**From:** Martyn White <Martyn.White@arun.gov.uk>  
**Sent:** 31 January 2020 17:18  
**To:** Zac Denton <Zac.Denton@arun.gov.uk>  
**Cc:** Planning.Responses <Planning.Responses@arun.gov.uk>  
**Subject:** AB/135/19/HH & AB/136/19/L

## **AB/135/19/HH & AB/136/19/L**

Proposed internal and external alterations including replacement of selected windows and doors and new ground floor terrace to provide more flexible family living accommodation and a lower ground floor annex.

Proposed External Doors - 1
Proposed

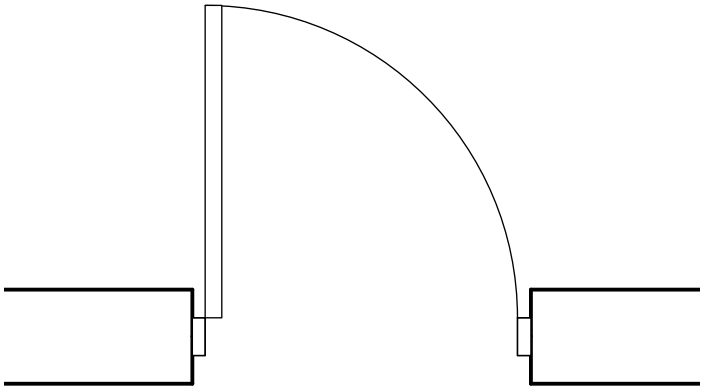
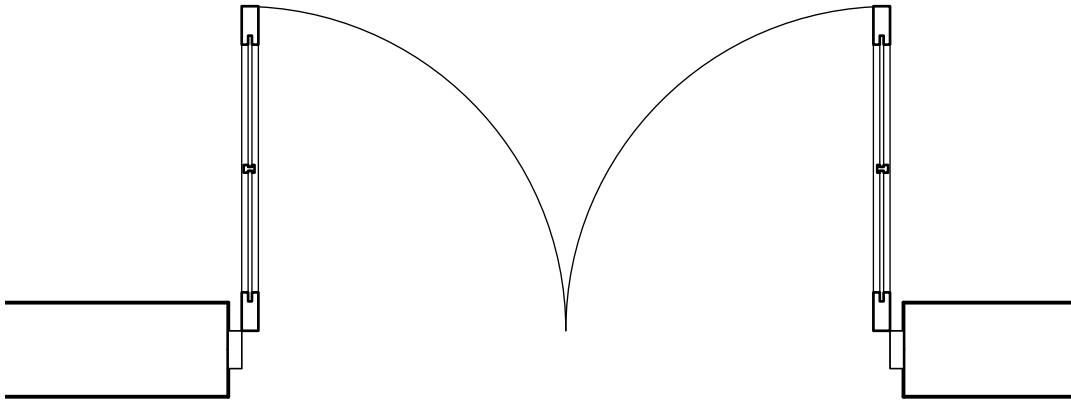
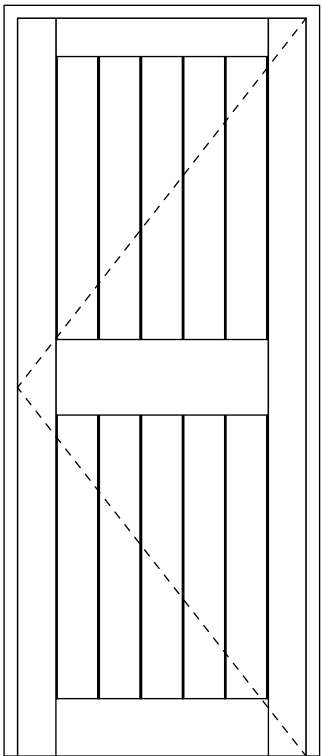
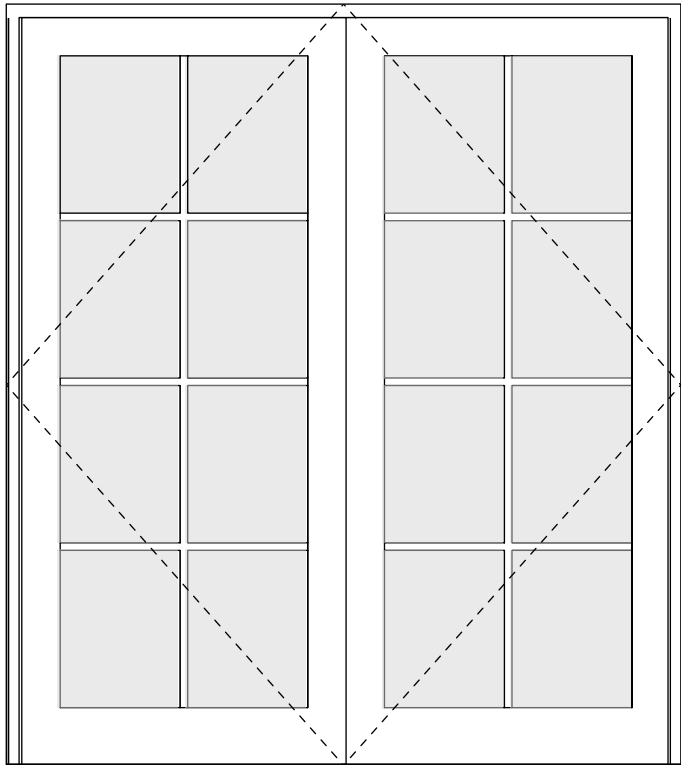
Details of all joinery, including any new cupboard doors should be provided to the LPA if minded to approve the application. Details of the colours of any external joinery should also be provided.

DRAWING TITLE
Proposed Internal Doors

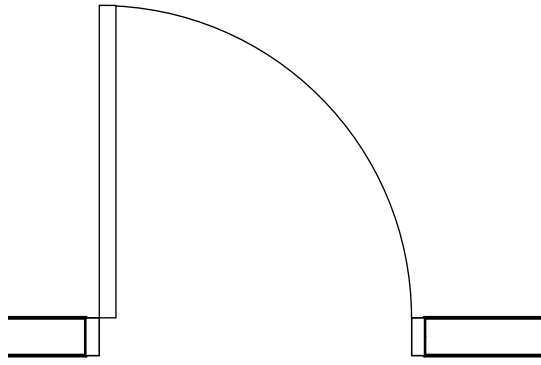
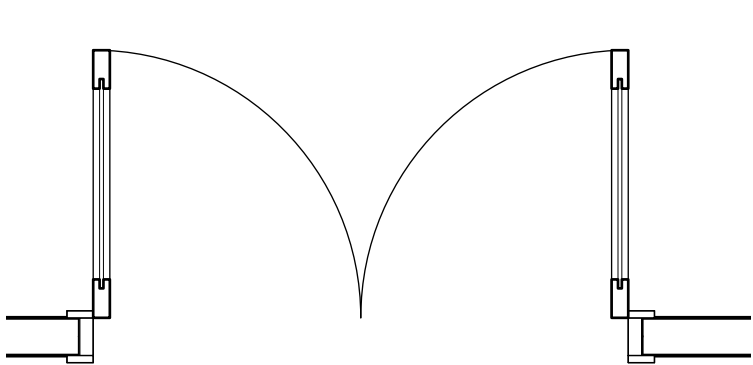
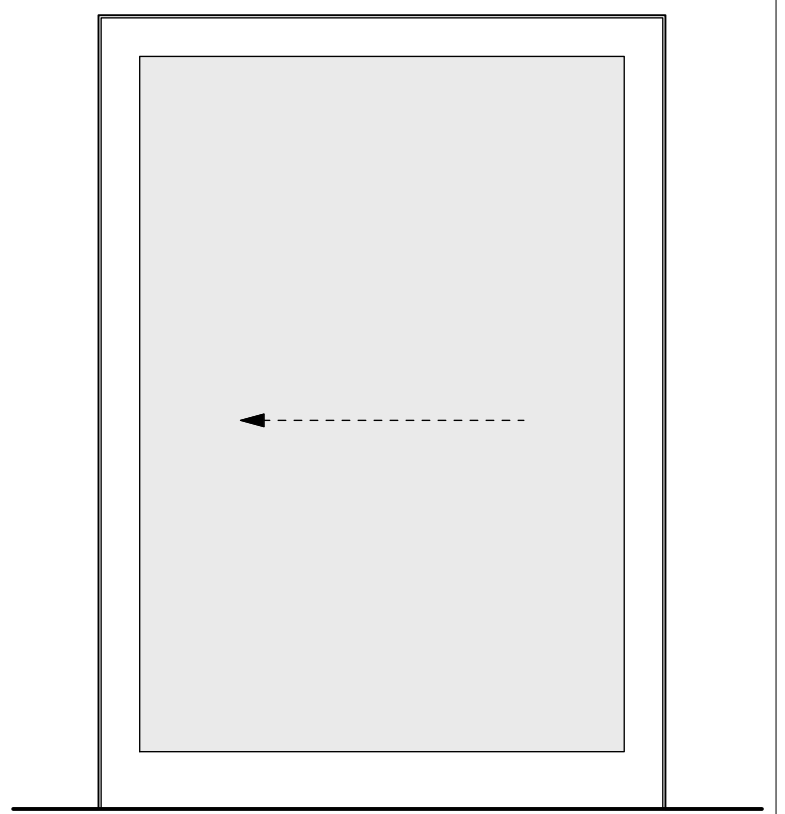
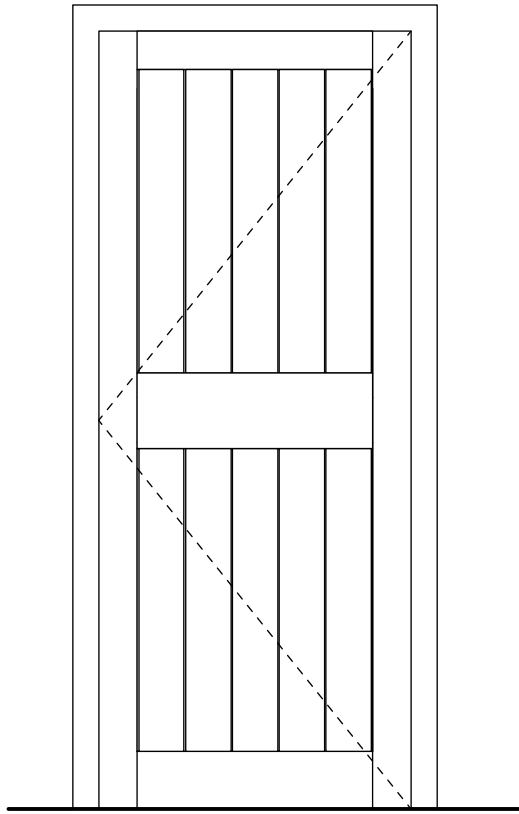
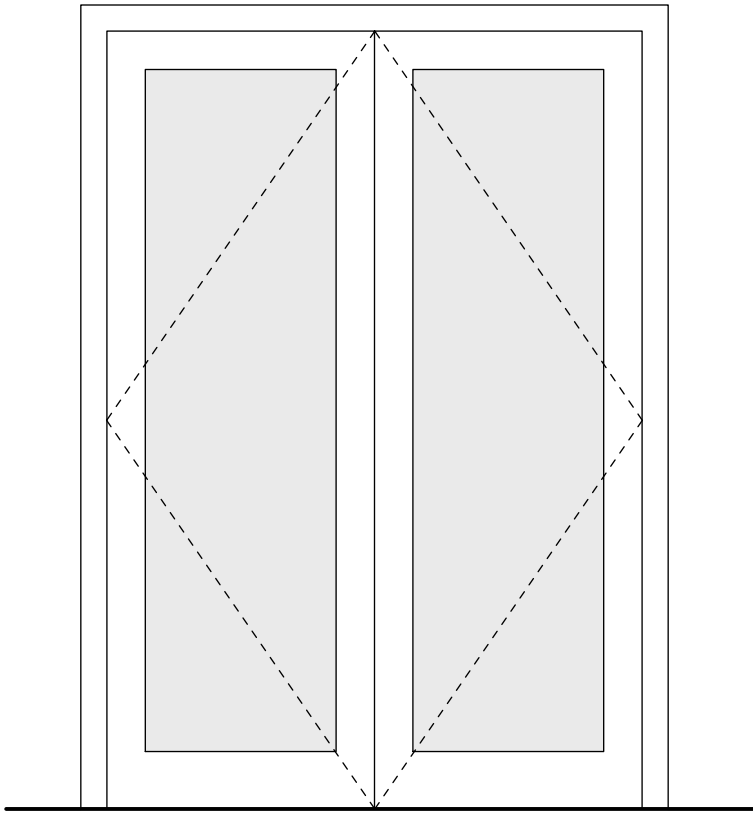
Details of the internal doors have been provided as part of the proposals; however, it is not clear why such a style has been chosen for all of the doors when they do not seem to reflect the character or Age of the building? At present they seem to be appropriate to a cottage, as opposed to a more genteel looking home, and are problematic.
